A38 Derby Junctions

**8.28 Statement of Common Ground with
Breadsall Parish Council**

Statement of Common Ground
Breadsall Parish Council

Version	Date	Status of Version
Final	17 March 2020	Deadline 8 Submission

Inset C- E - Little Eaton junction

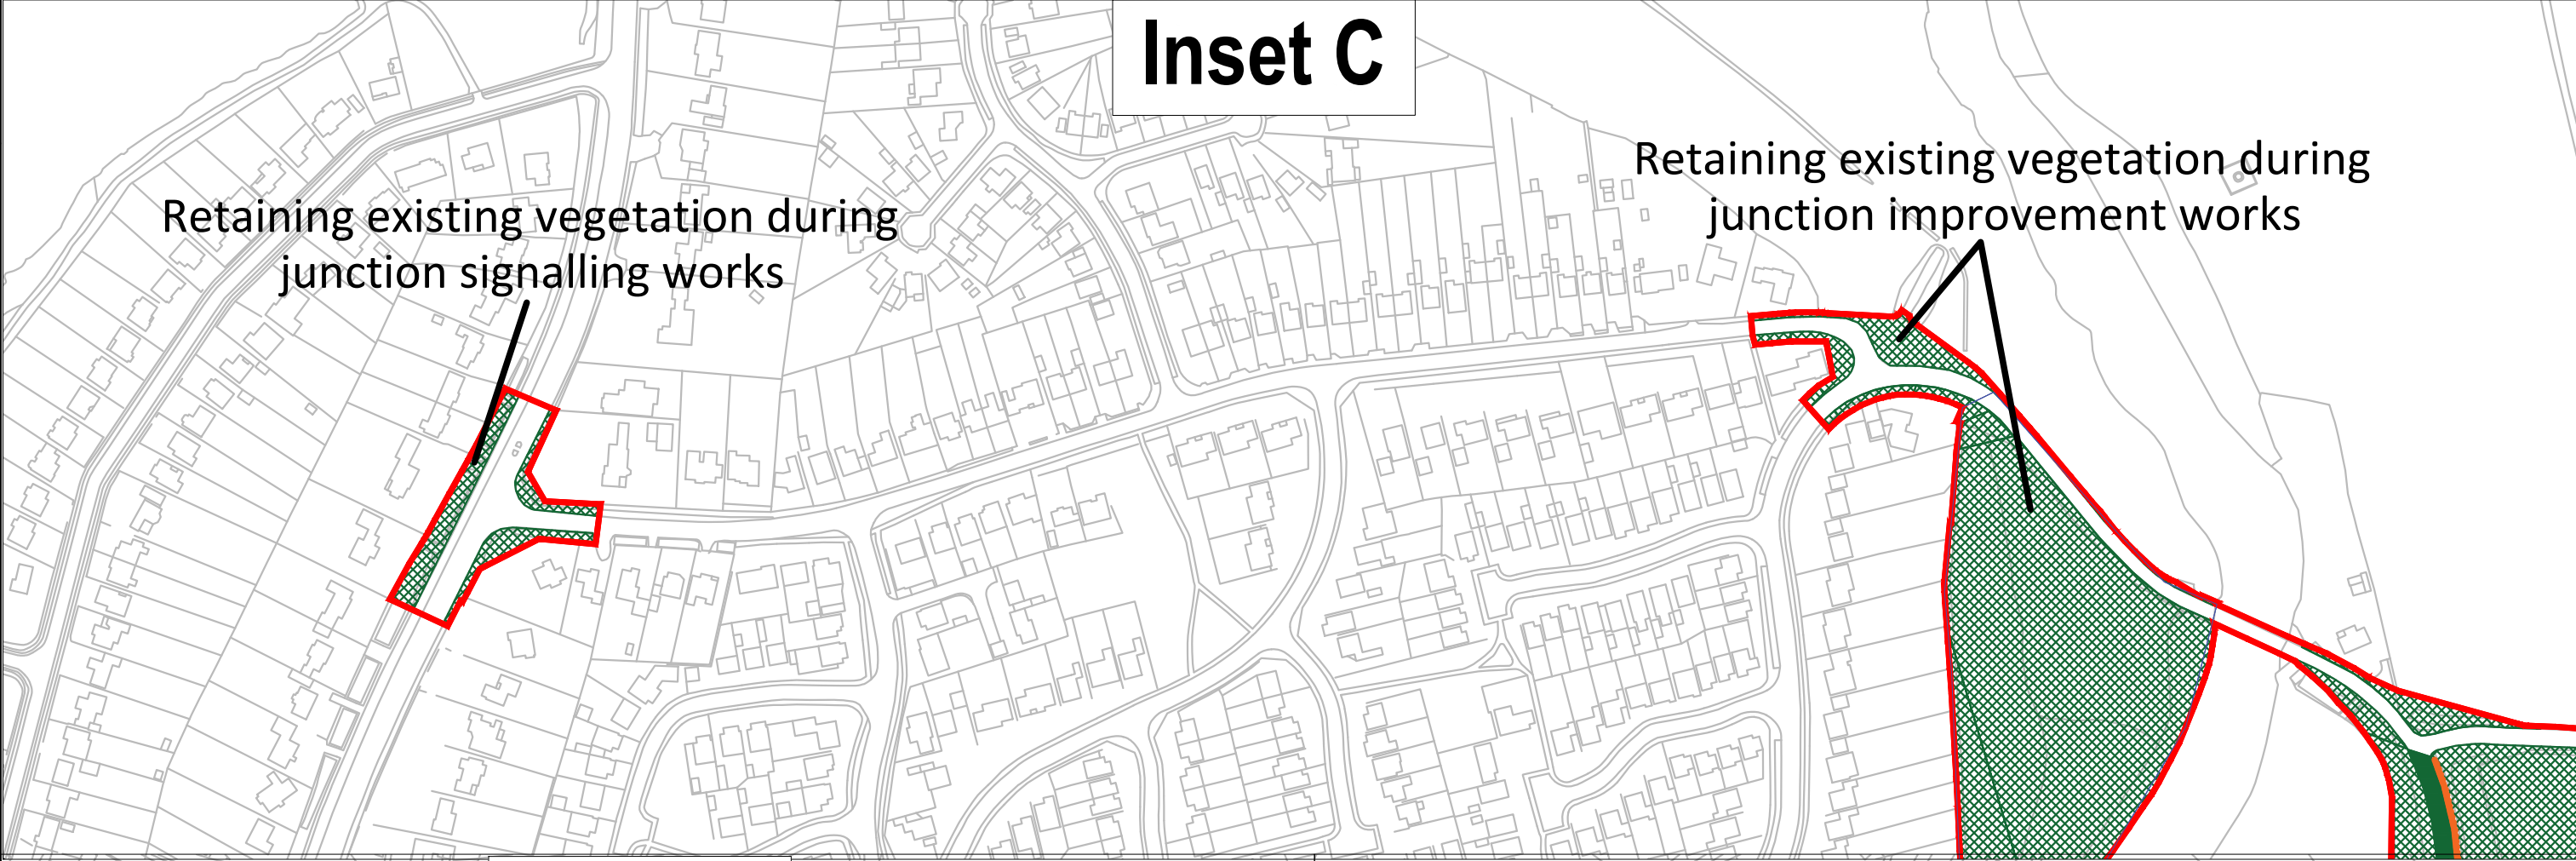
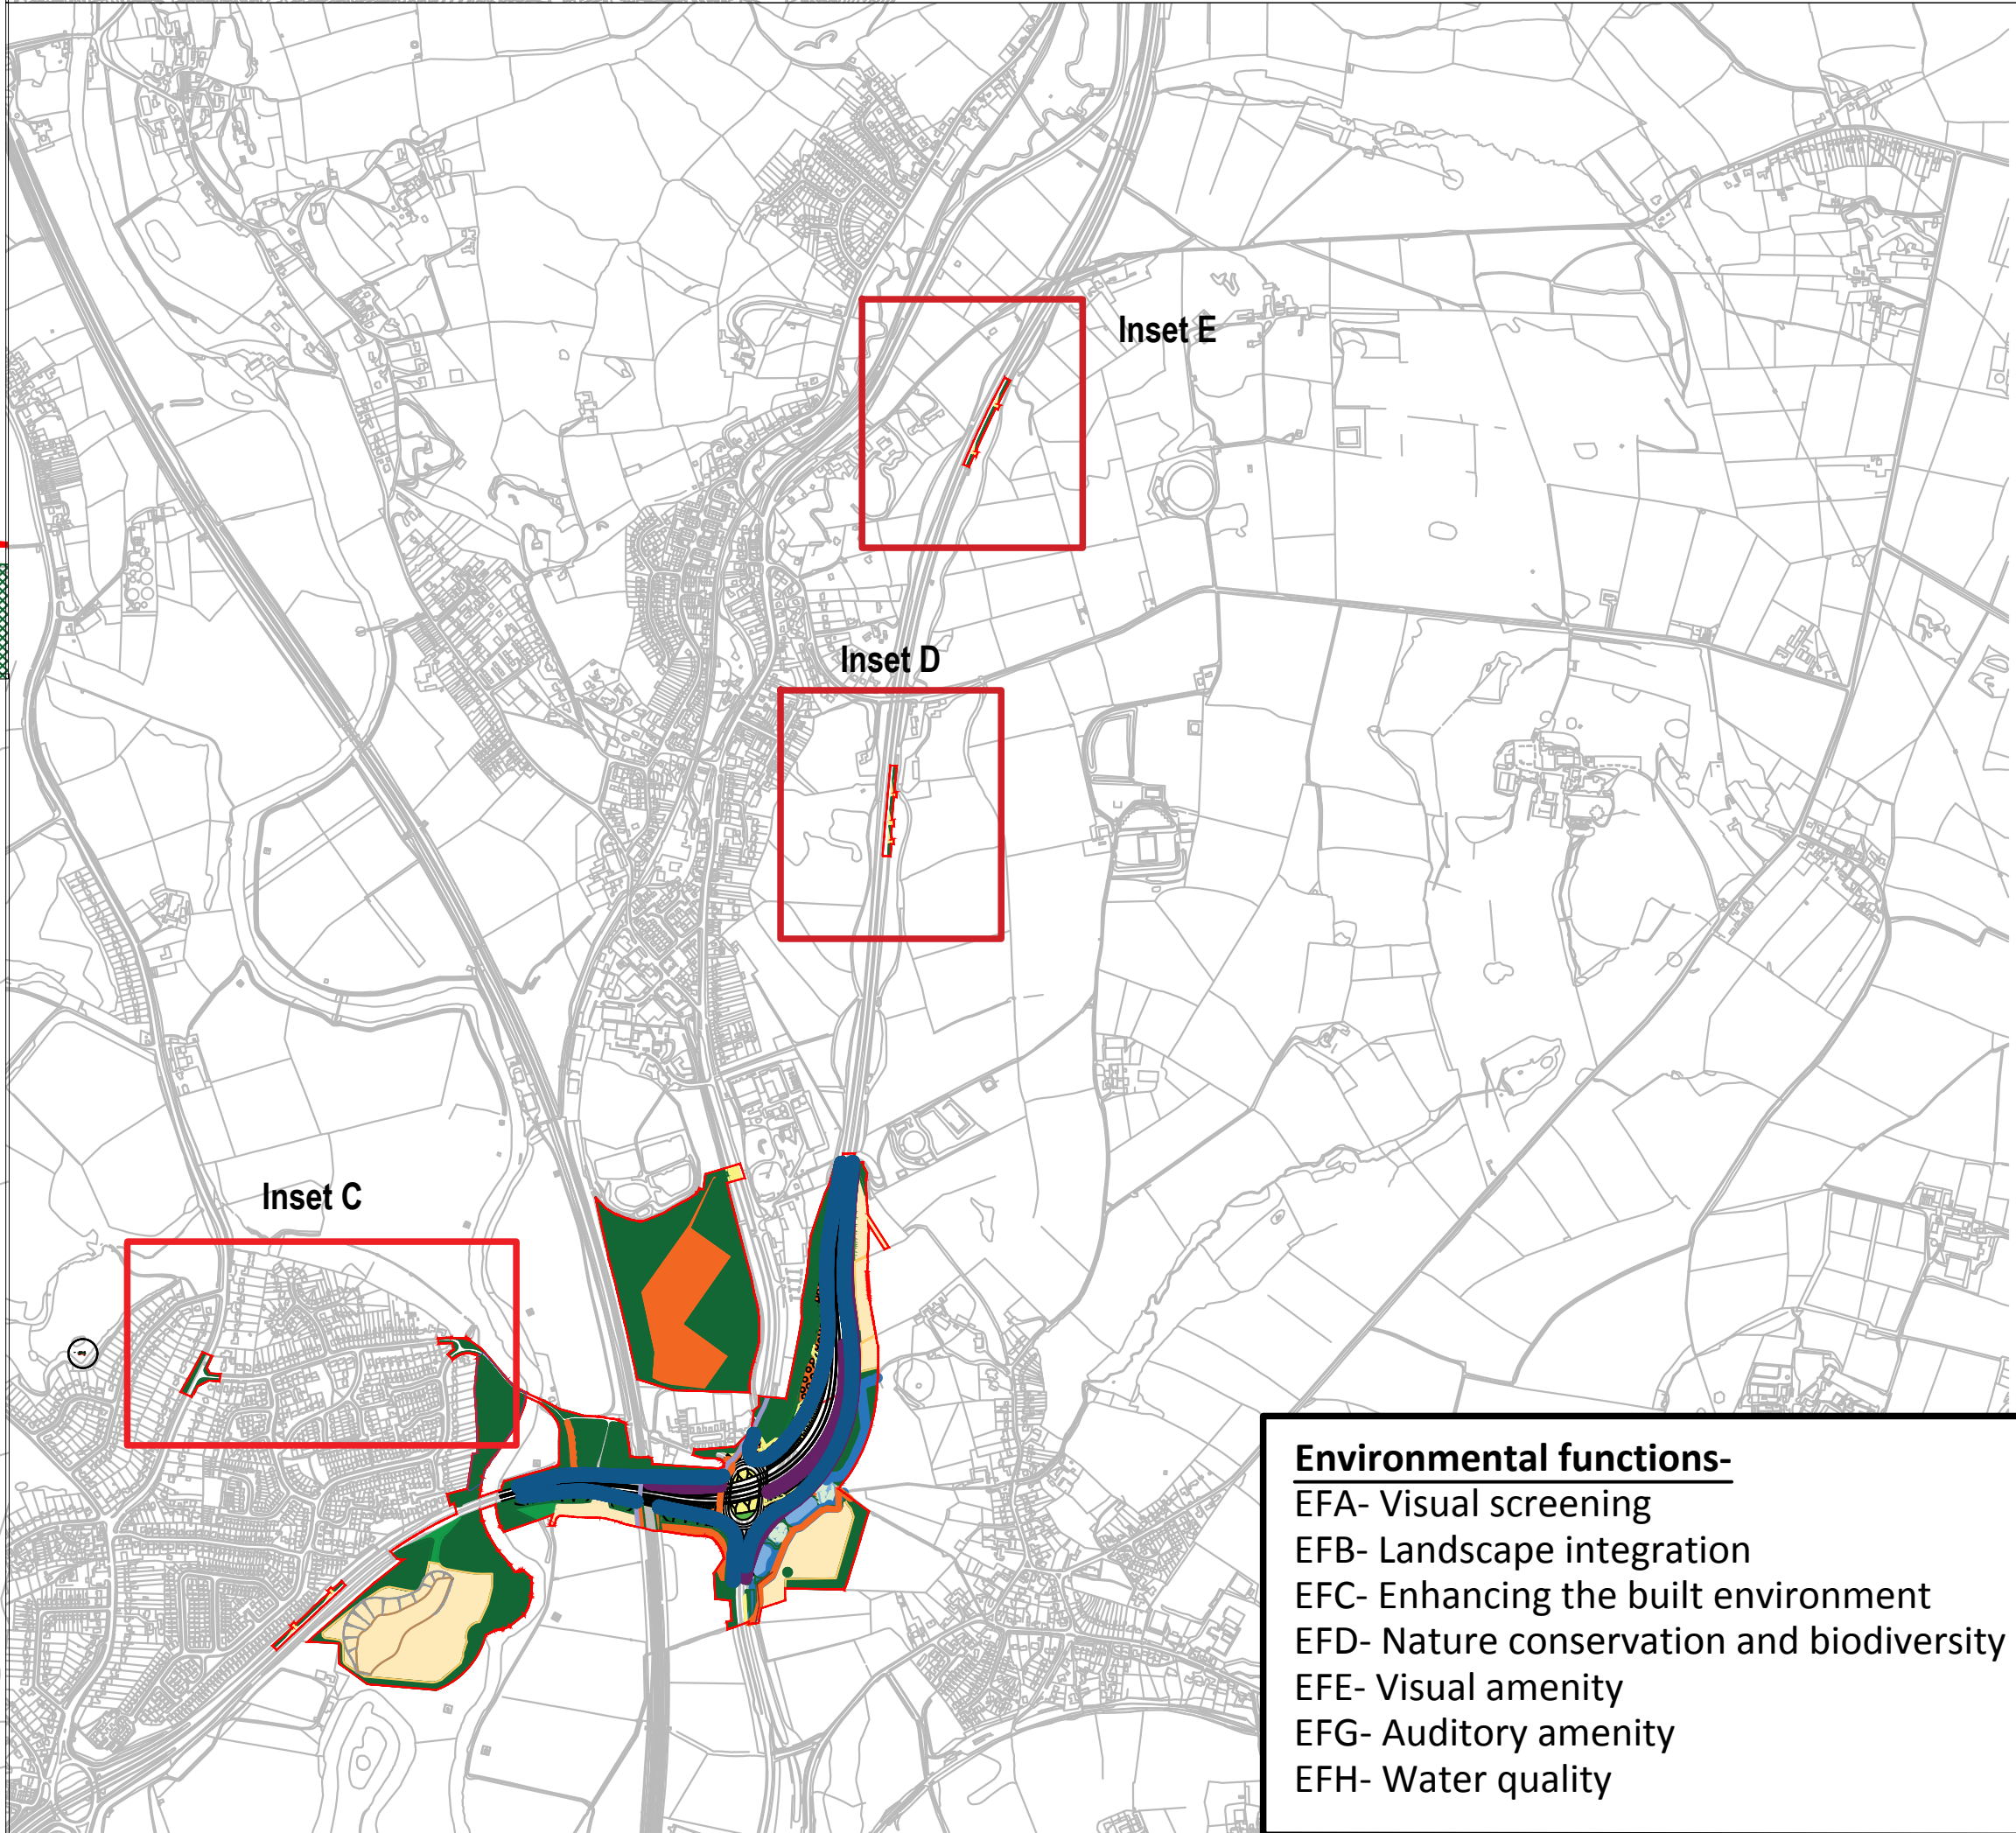
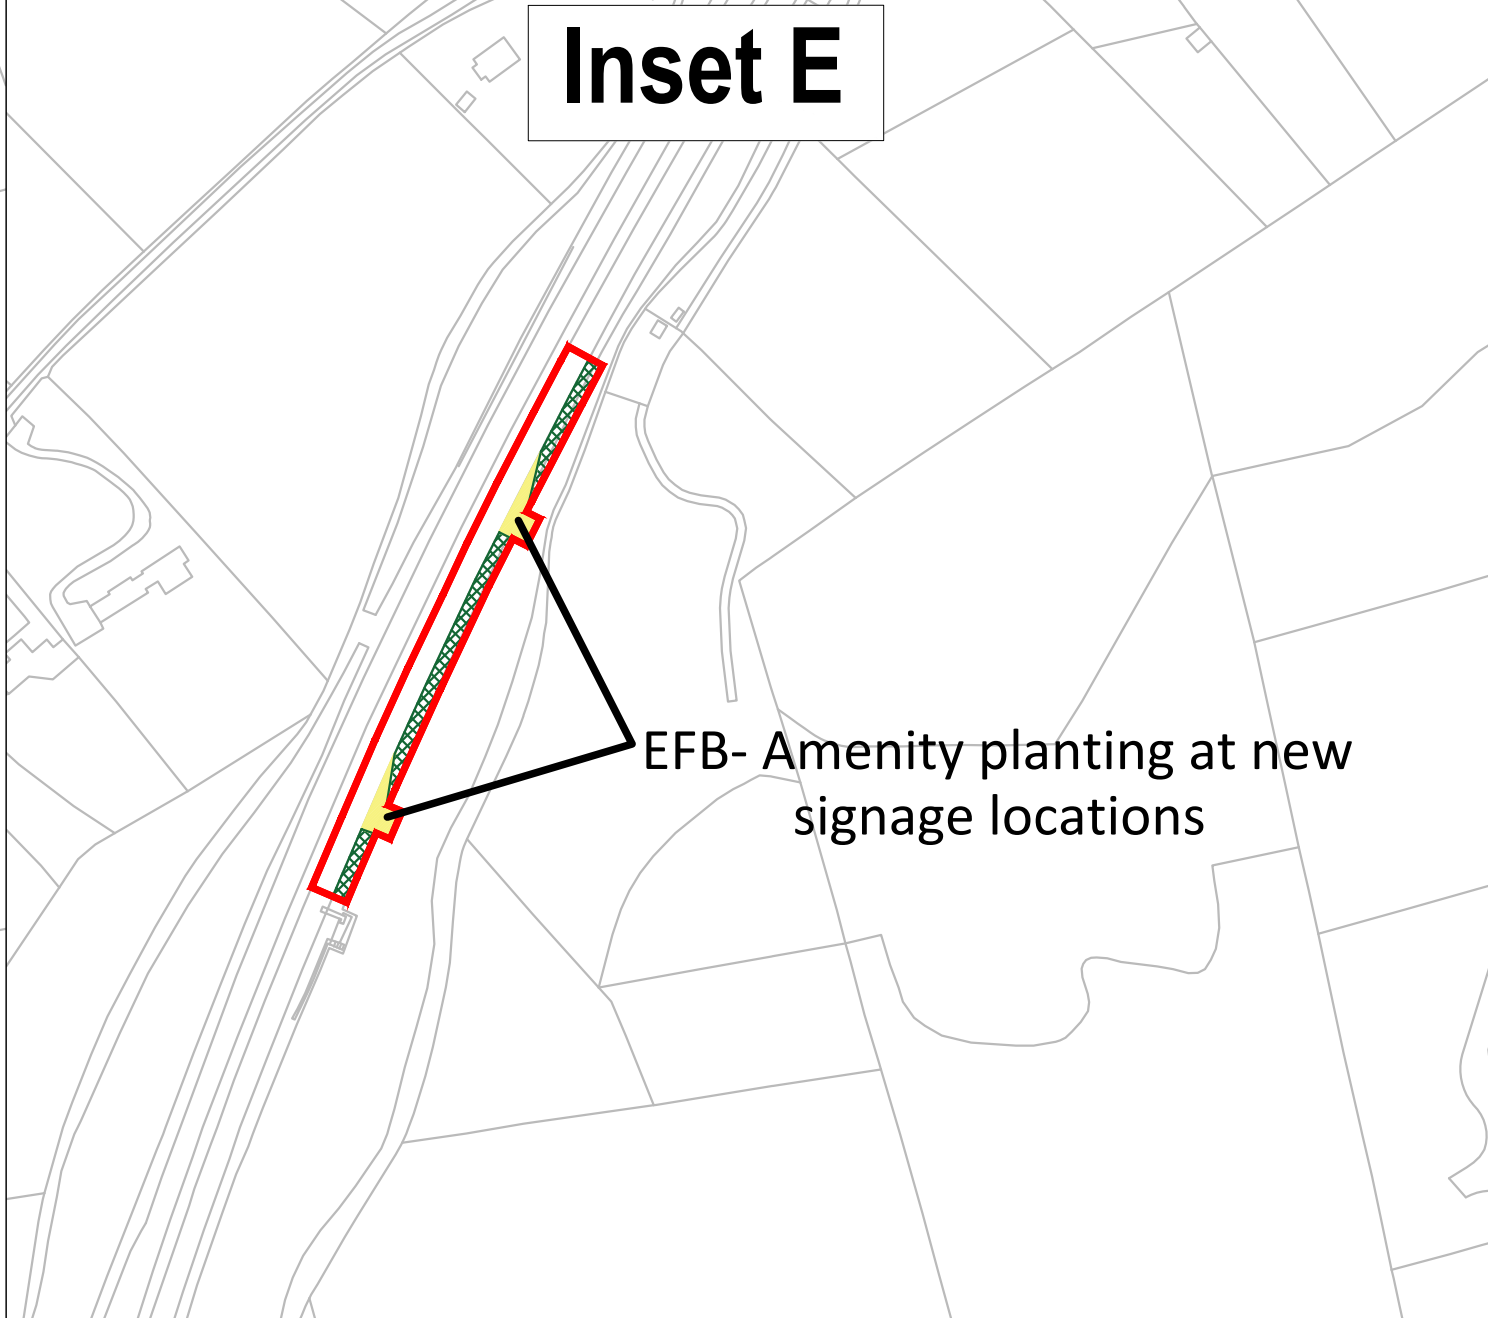
noise generation than a standard hot rolled asphalt surface. The use of low noise thin surfacing can reduce noise levels by 3.5dB at speeds of ≥ 75 km/hr.		
ES Chapter 9 – Noise and Vibration and Environmental Masterplans	[APP-047] [APP-068]	and	Noise and screening barriers at Little Eaton junction	BPC has highlighted that noise/ visual screening barriers at Little Eaton junction are essential. BPC would like to be consulted in relation to the detailed specification of the effectiveness, the durability and appearance of the barriers. BPC also require confirmation that the barriers would be suitably maintained.	In order to mitigate noise and visual effects, the Scheme design includes the following noise/ visual screening barriers: <ul style="list-style-type: none"> • 2.5m reflective noise/ screening barrier on the southbound diverge slip road to the A61 at Little Eaton junction. • 2.5m reflective/ absorptive noise/ screening barrier on the southbound A38 mainline at Little Eaton junction. • 2.5m reflective noise/ screening barrier on the northbound A38 mainline at Little Eaton in the vicinity of the Ford Farm Mobile Home Park. Such barriers are illustrated on the Environmental Masterplan ES Figures 2.12F and 2.12G [APP-068] . The two Highways England responses below are also of relevance to BPC's comment.	Agreed
